## **BMBC Pollution Control**

Before use of the development commences, the noise mitigation measures described in report 'Noise Impact Assessment' produced by Environmental Noise Solutions Ltd dated 7 February 2024, ref: NIA-11108-24-11392-v4 Hemmingfield Road, shall be implemented so that environmental noise does not cause significant adverse impacts on health or the quality of life as required by noise planning policy, to those living and working in the development. This includes:

Figure C4: Mitigation requirements

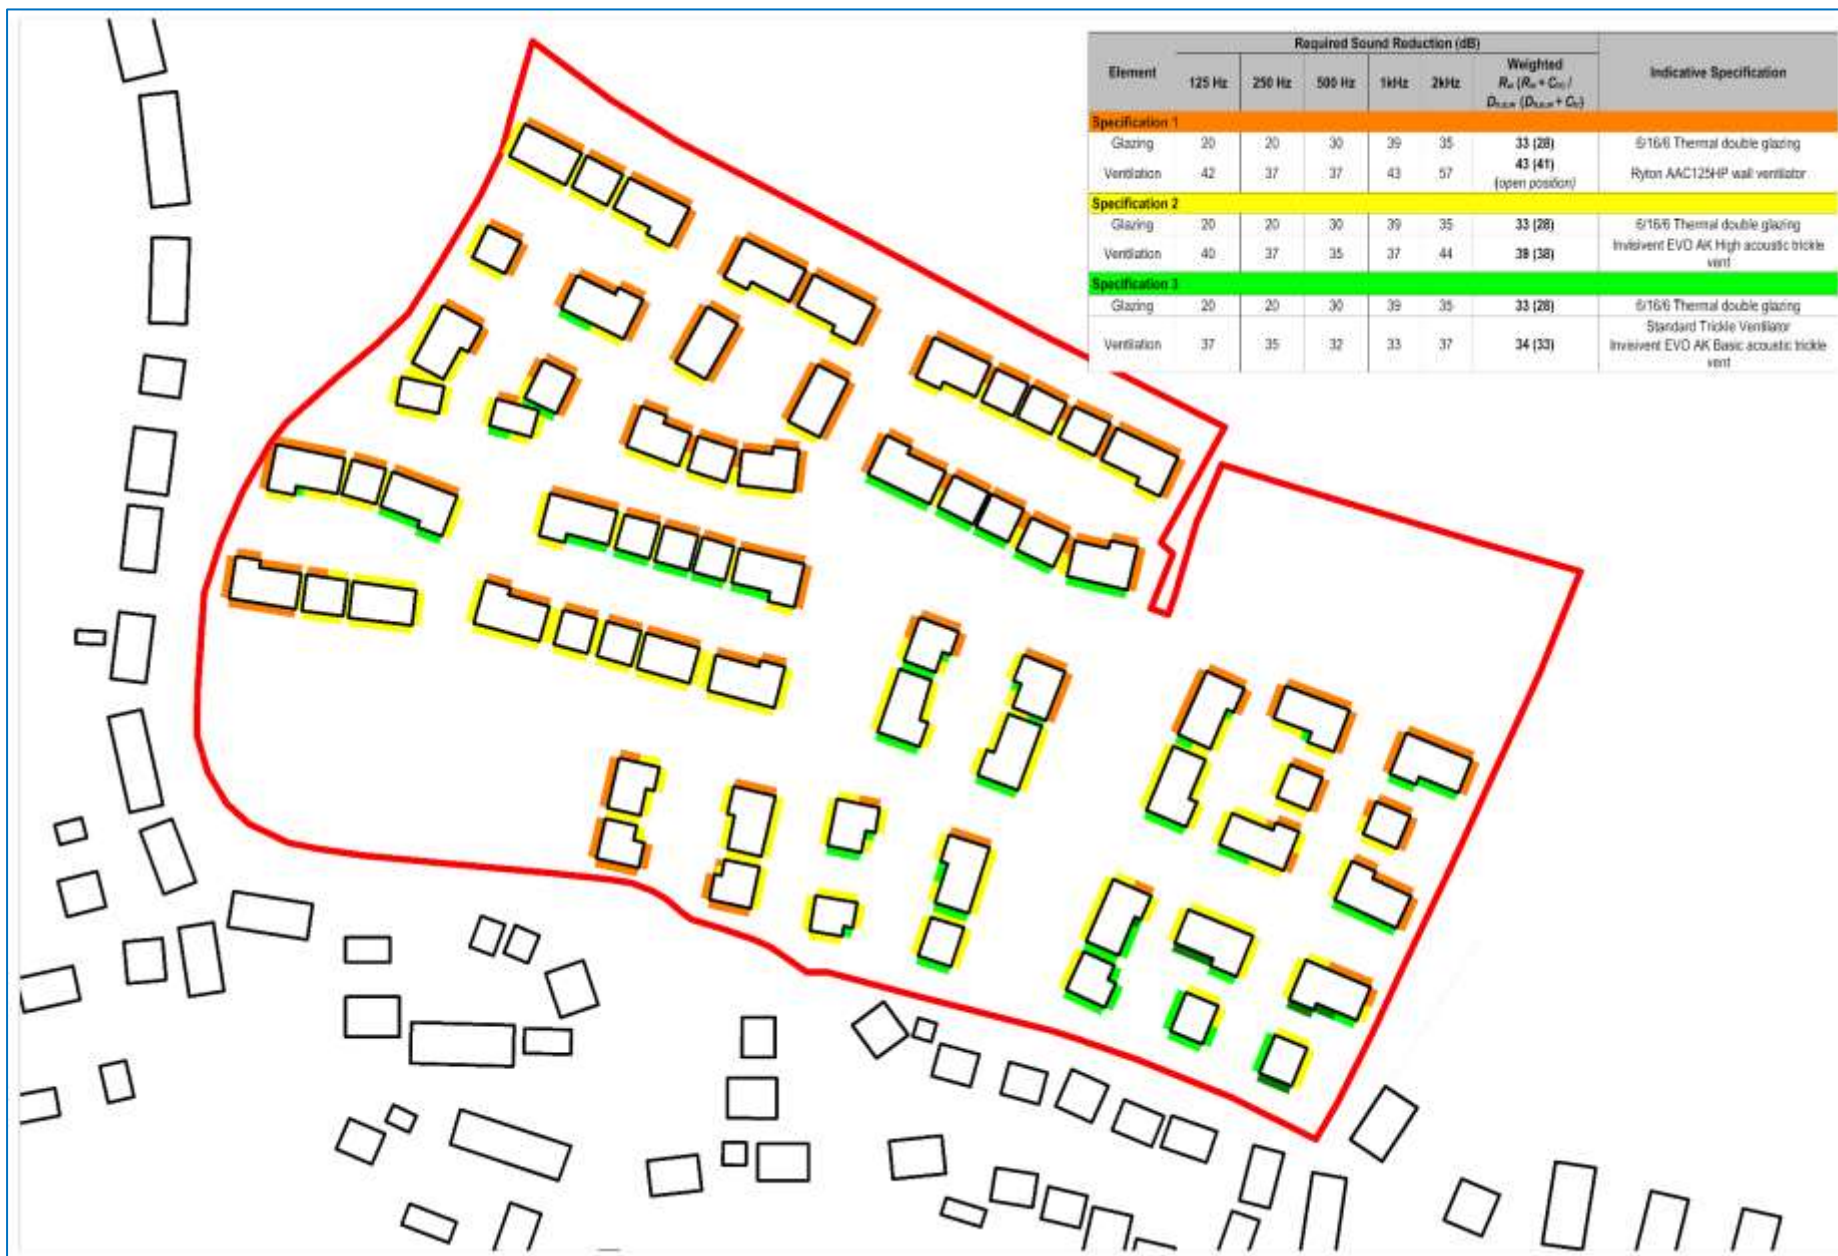
- All glazing and ventilation installed shall meet the criteria detailed within the Noise Impact Assessment above
- Acoustic trickle ventilators or through wall ventilation shall be installed in every habitable room (one per bedroom and two for other habitable rooms)
- Close boarded timber fencing of at least 1.8m height shall be used in every garden

Once the final layout is submitted and agreed by the Local Planning Authority an updated noise mitigation plan shall be submitted and agreed by the Local Planning Authority. The scheme shall be maintained and not altered without the prior permission of the Local Planning Authority.
